<b>Consultation Response from KC, Lead Local Flood Authority</b>
<b>2025/91781 Bradley Villa Farm, Bradley Road, Bradley, Huddersfield, HD2 2JY</b>
<b>Discharge of details reserved by conditions 9 (cycle parking), 10 (electric vehicle charging), 11 (waste storage and collection), 12 (temporary drainage), 13 (drainage scheme), 14 (flood routing), 15 (Phase II report), 19 (external materials), 20 (boundary treatments), 21 (external lighting), 23 (BNG assessment) and 24 (Biodiversity Gain Plan) of previous permission 2023/92887 for change of use of egg production unit to research and development or industrial uses falling within E(g)(ii) and (iii) Use Class, and associated elevational alterations and provision of access, gates, forecourt, parking areas and landscaping</b>
<b>Date Responded: 8<sup>th</sup> May 2026 Responding Officer: Paul Farndale Responding Ref: 3</b>

**Condition 12 – Temporary Drainage (Construction Phase Flood Risk/Pollution Mitigation)**

TITLE
TEMPORARY SURFACE WATER MANAGEMENT PLAN

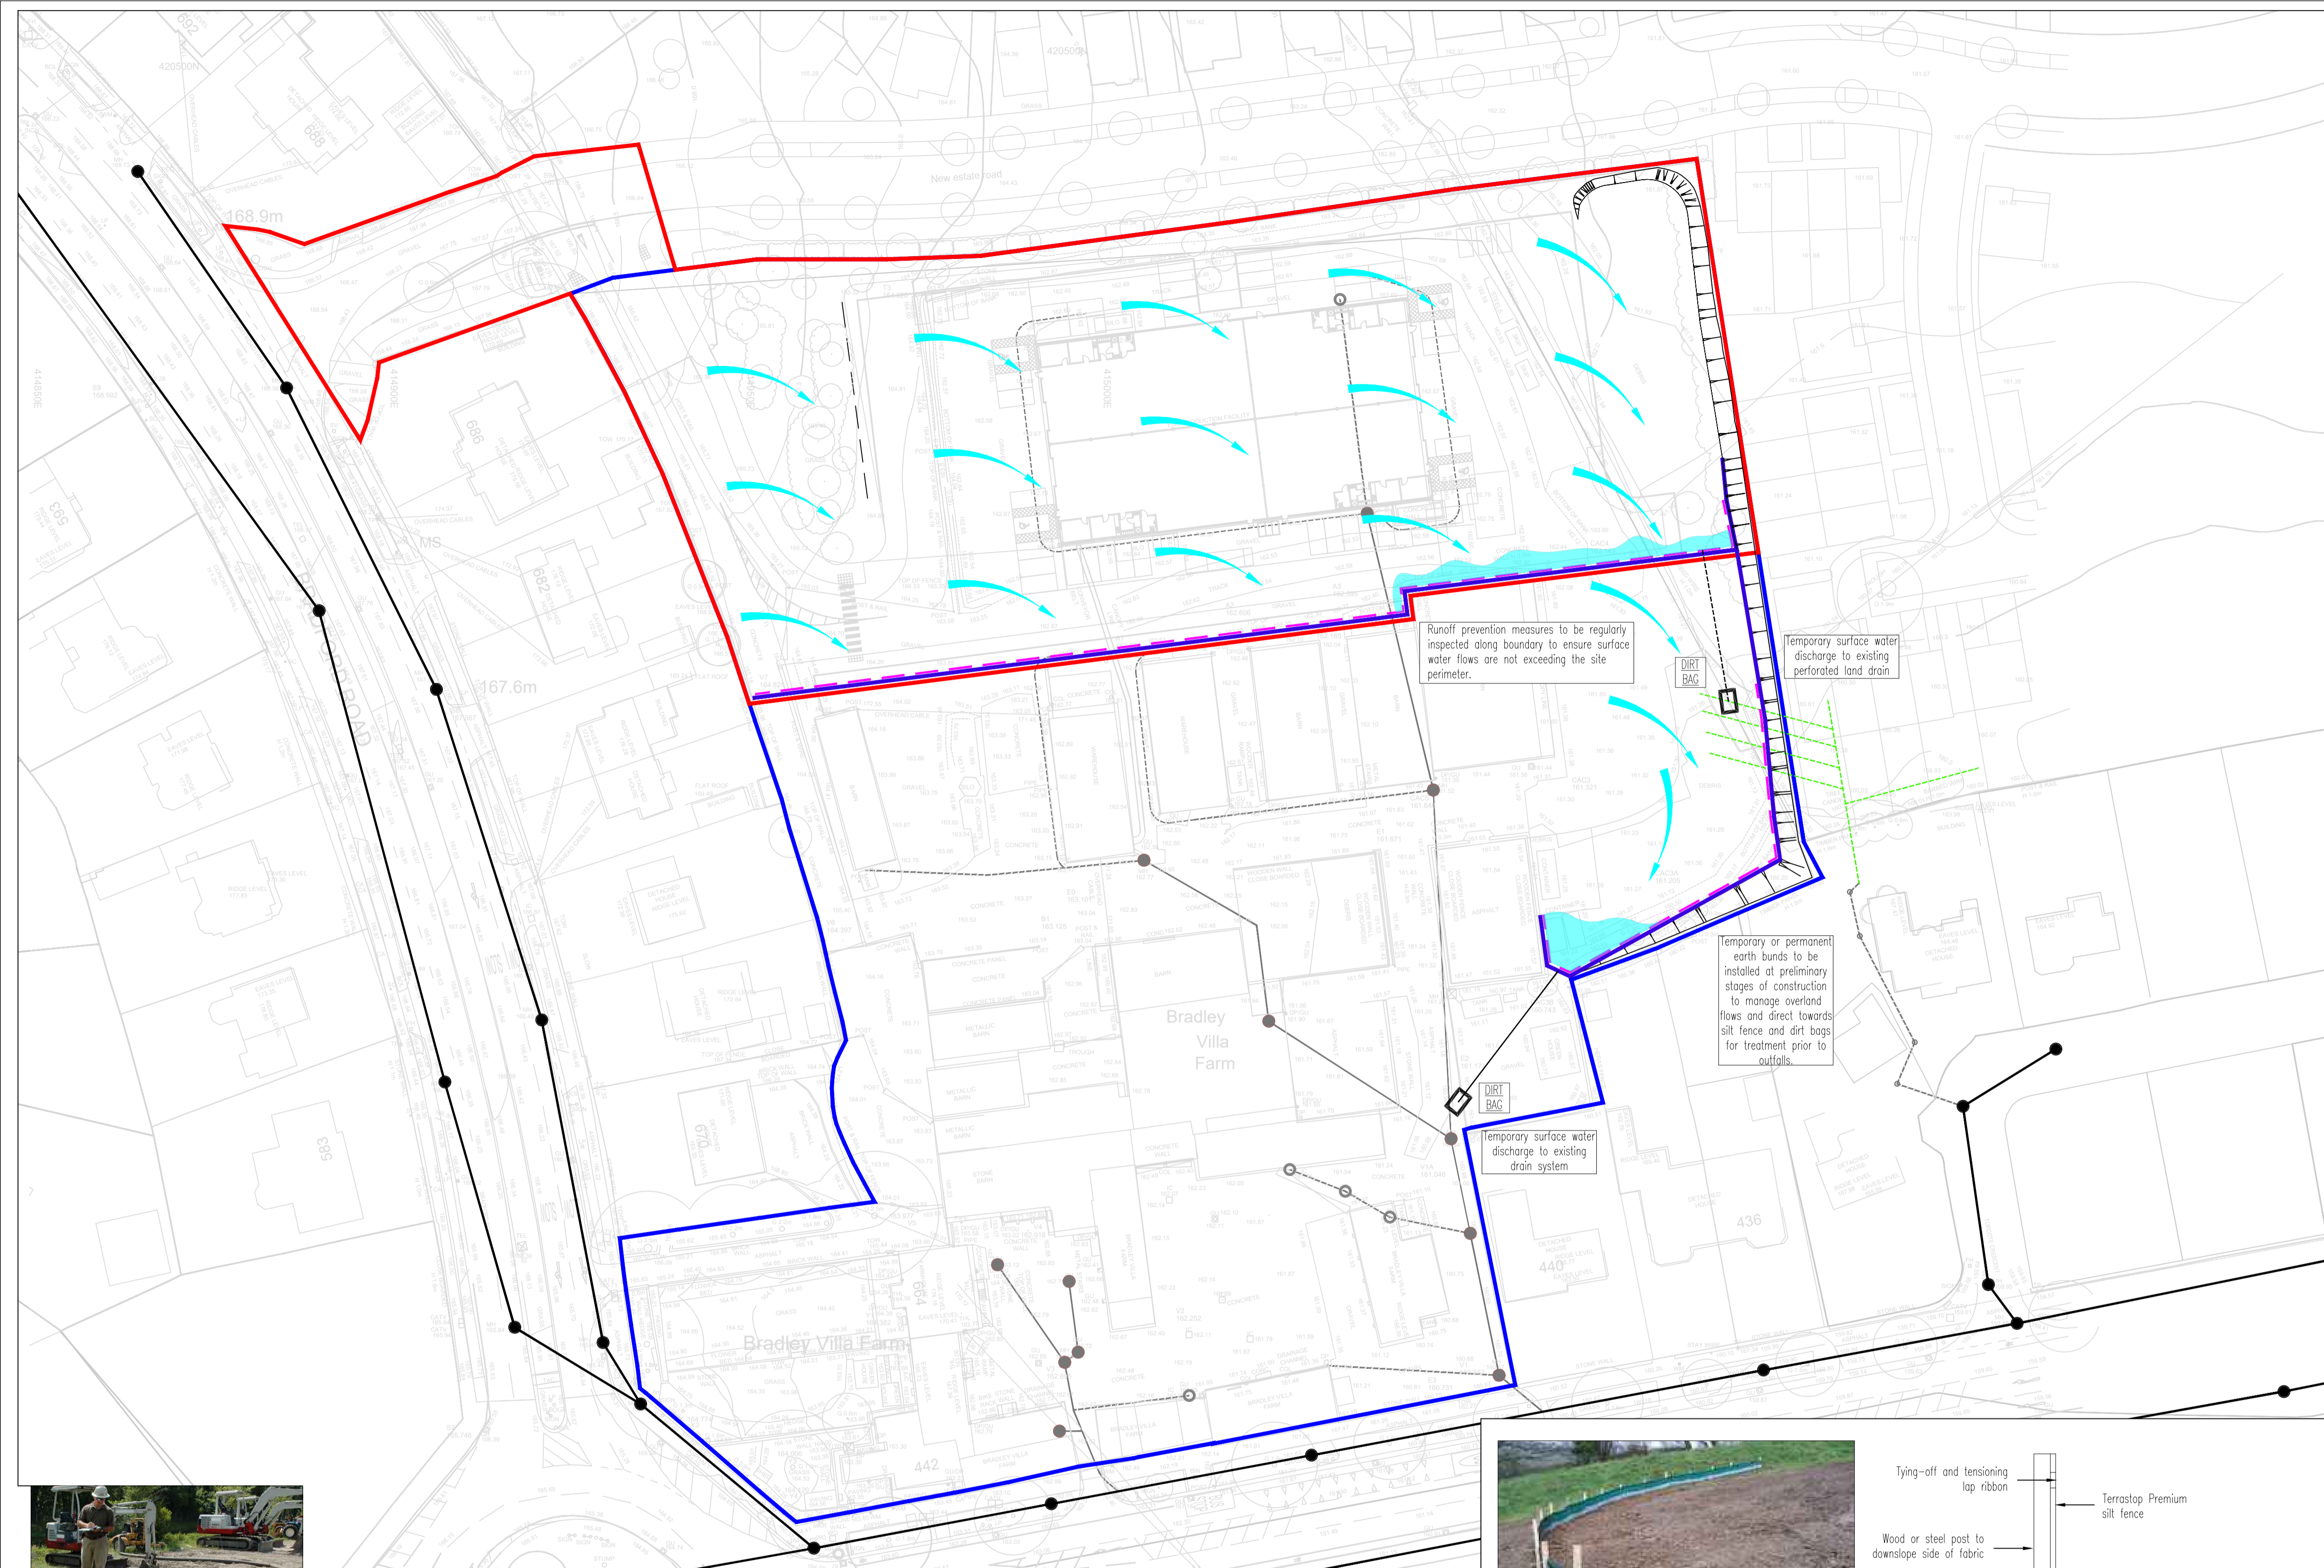
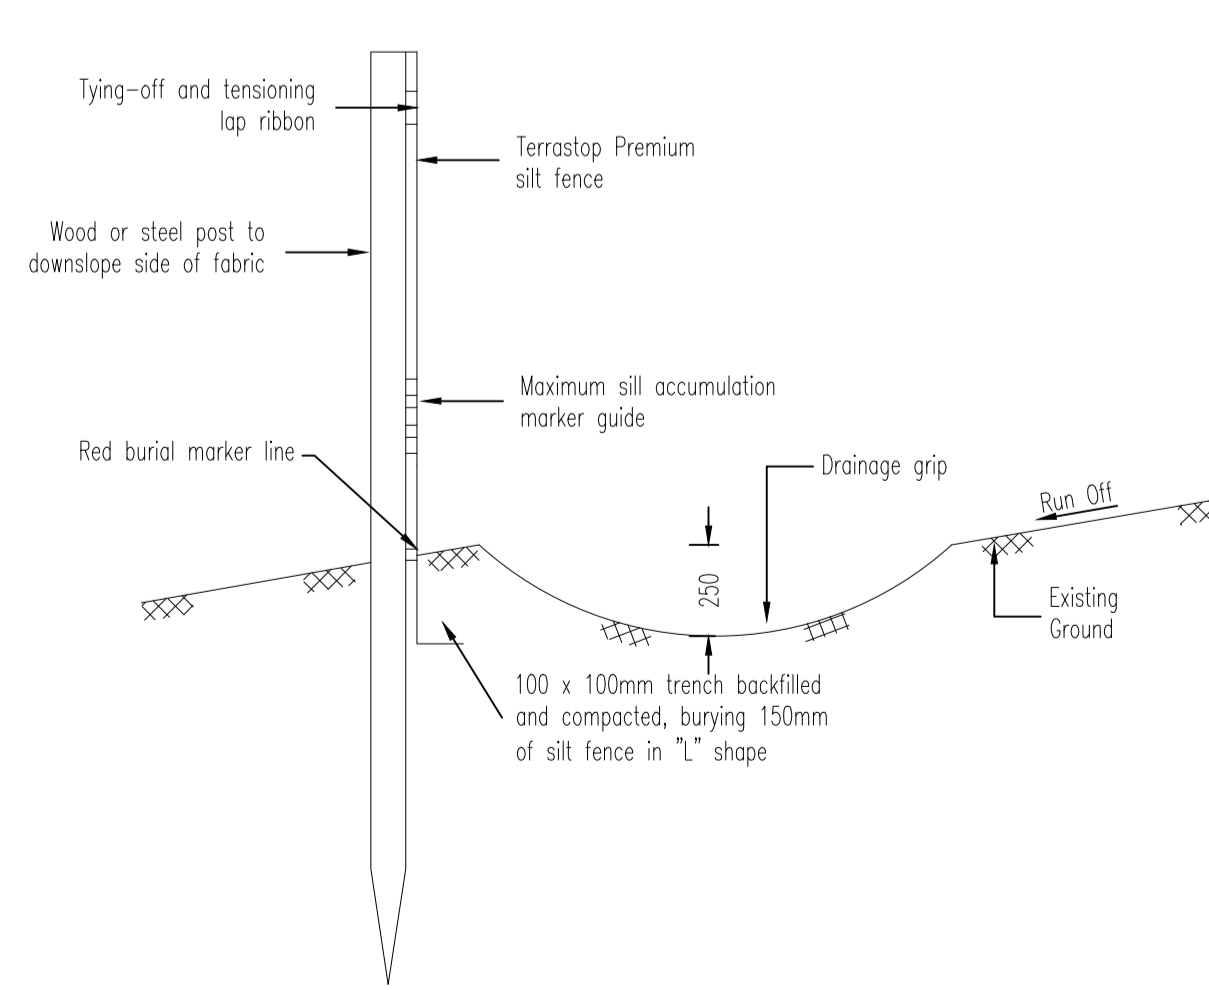
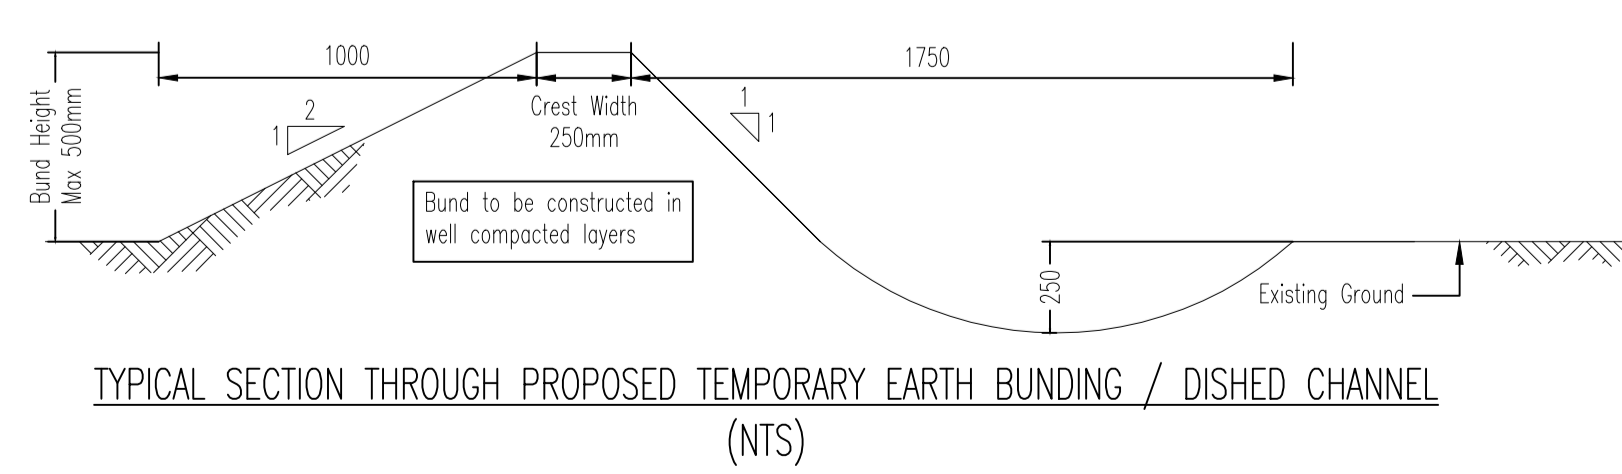
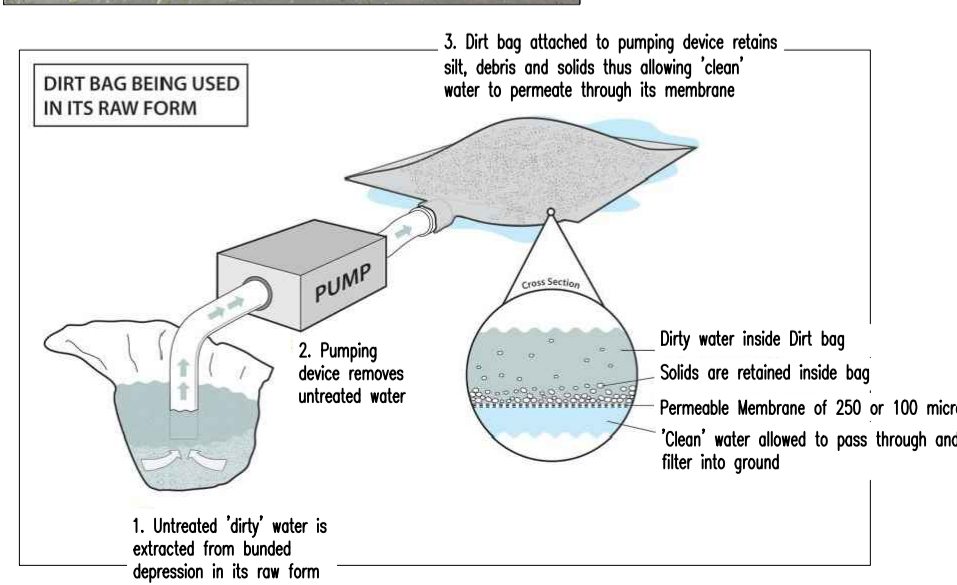
A management plan submitted on a drawing is deemed acceptable and proportionate for his development.

**We recommend this condition can be discharged.**
